PLANNING CONSULTATION RESPONSE

Application No	2026/0422
Proposal	Residential development of up to 144 units and associated works
Address	Land to the south of Weetshaw Lane Roundabout, Cudworth, Barnsley
Date of Consultation Reply	14 th August 2026
Consultee	Strategic Housing

APPENDIX C – Topographic Survey

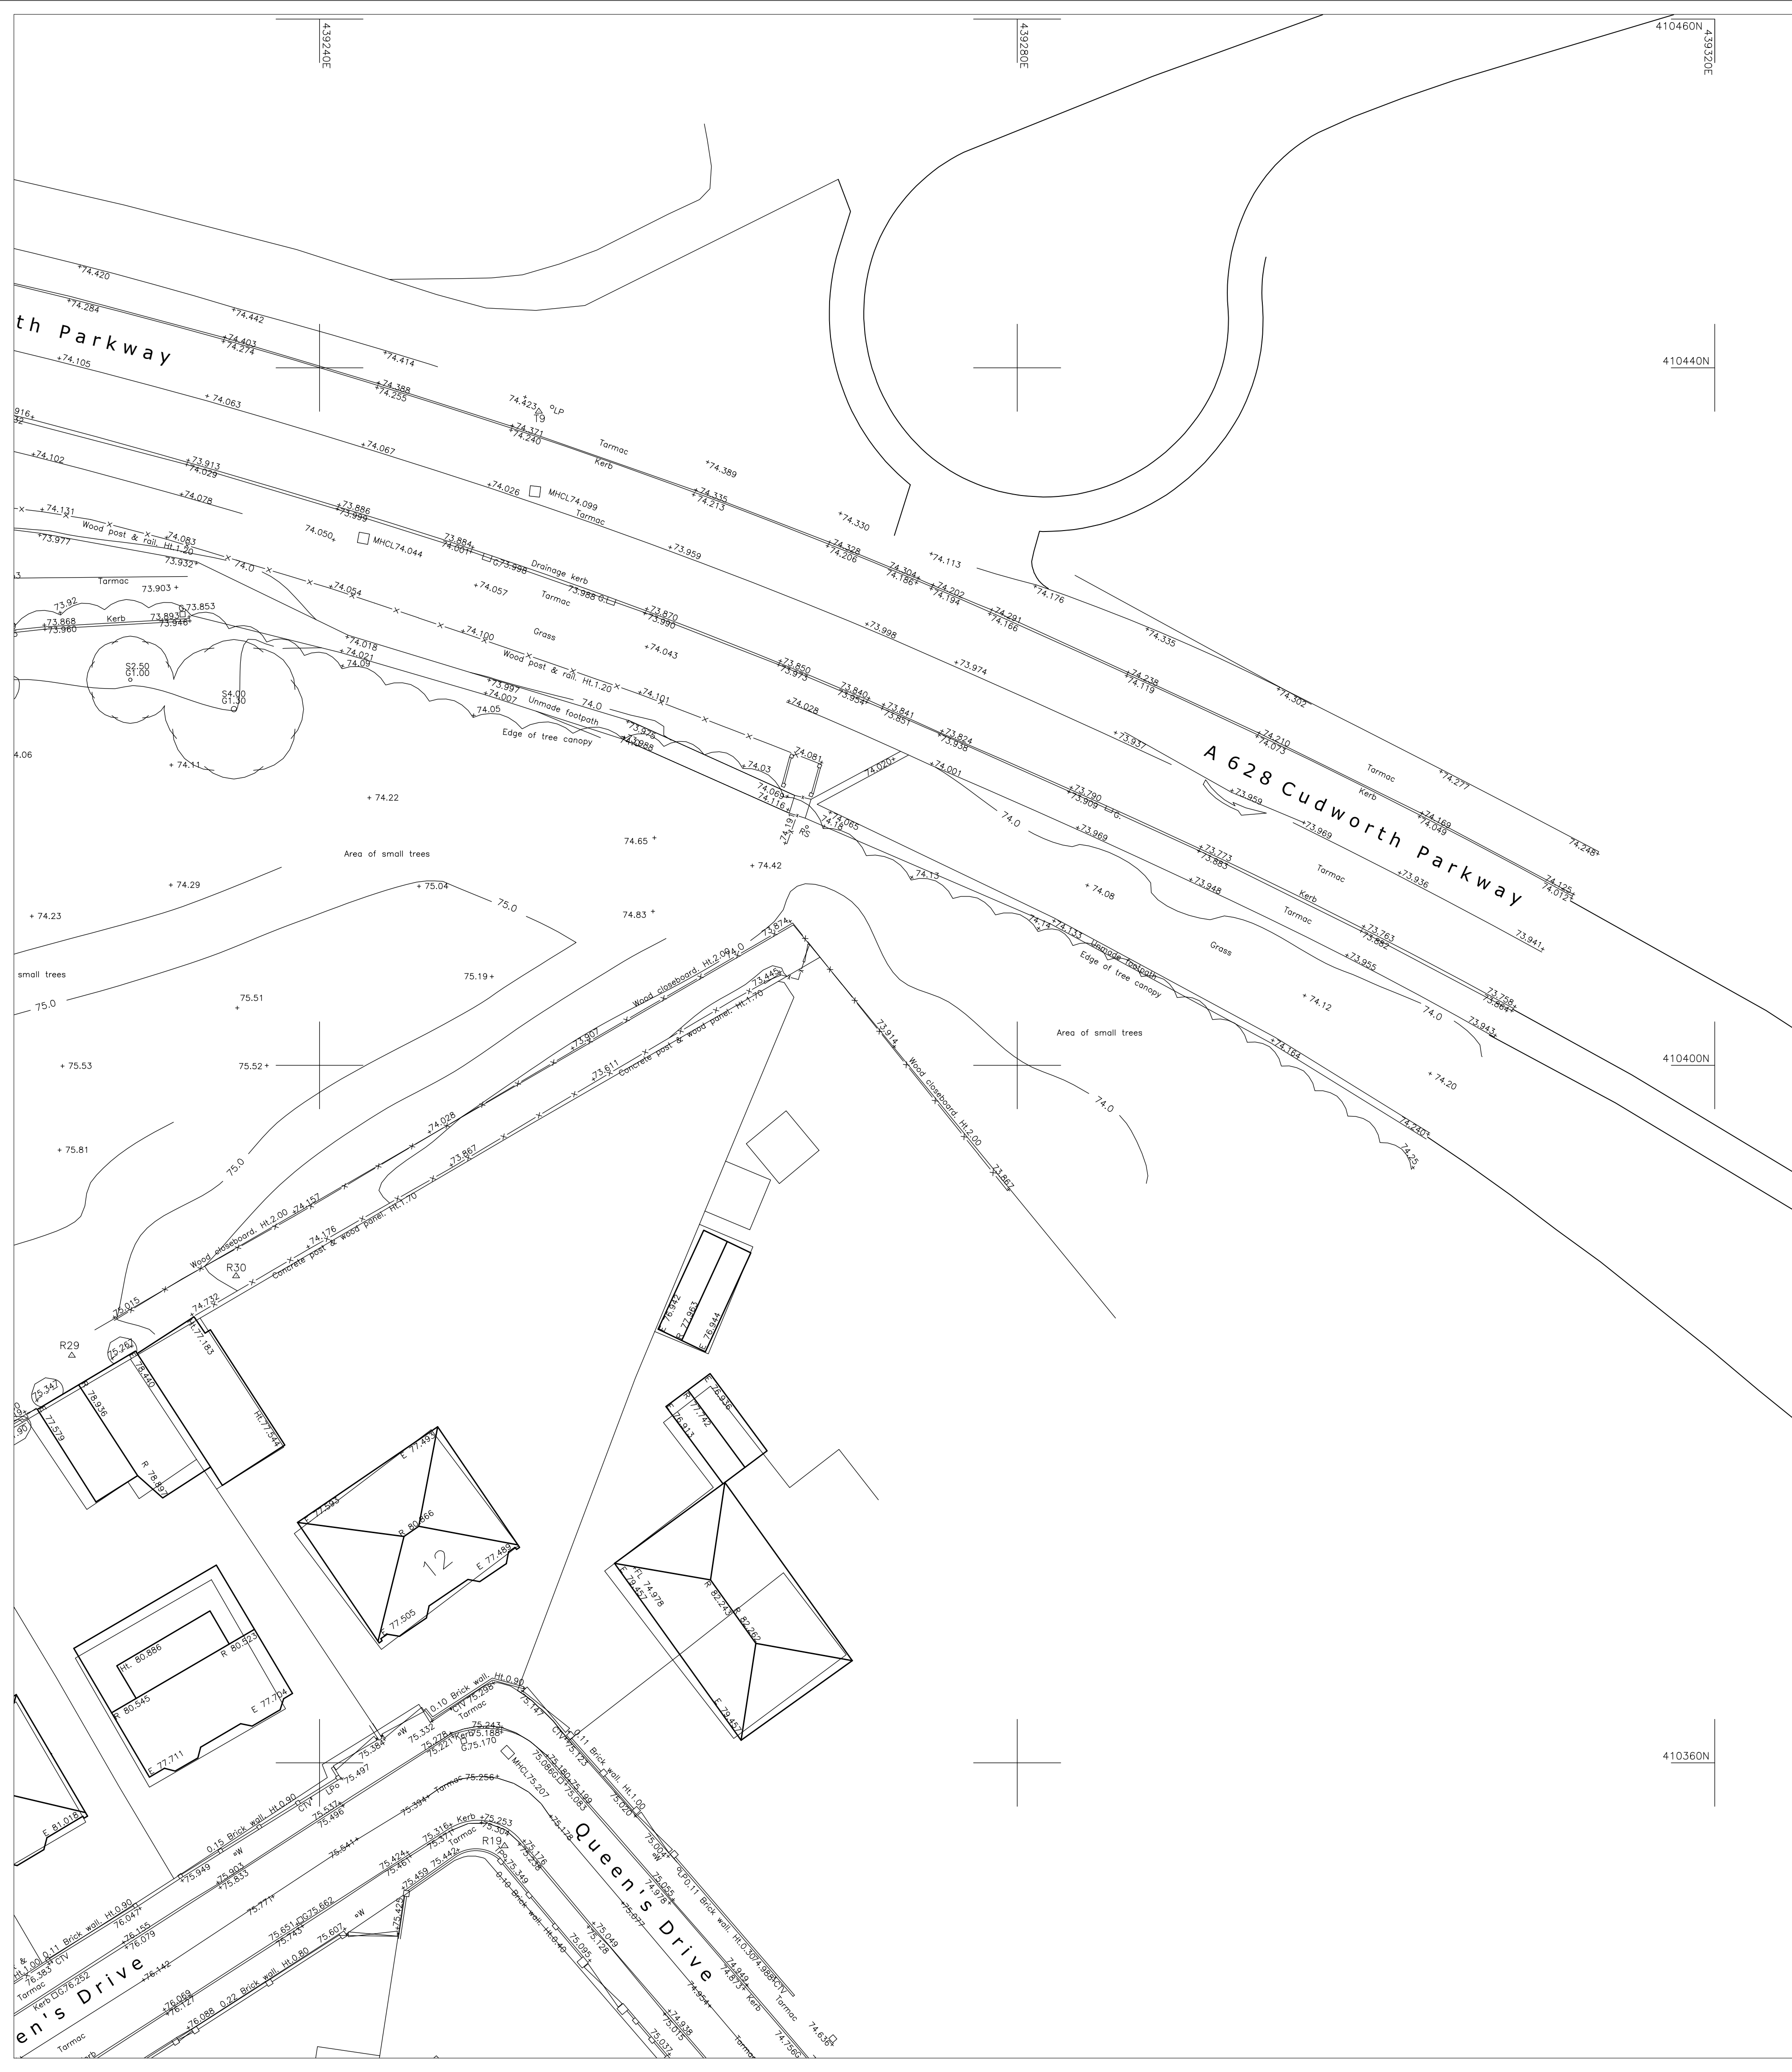
On the Proposed Site Plan, the affordable units are marked with a yellow dot. None of the four-bedroom dwellings (coloured green) are marked as affordable. The council would welcome the inclusion of 4-bed affordable units as there is a borough wide need for larger family accommodation for social and affordable rent.

The Proposed Site Plan does identify the affordable plots. These are dispersed across the larger section of the site, but the western area has no affordable plots.

The applicant should identify the accessible, affordable dwellings on the proposed site plan for ease of reference.

In response to the comments in the Property Type and Tenure sections, the applicant should review the location of the affordable units once their proposed mix of house types is confirmed. Consideration should also be given to including affordable units in the western section of the site.
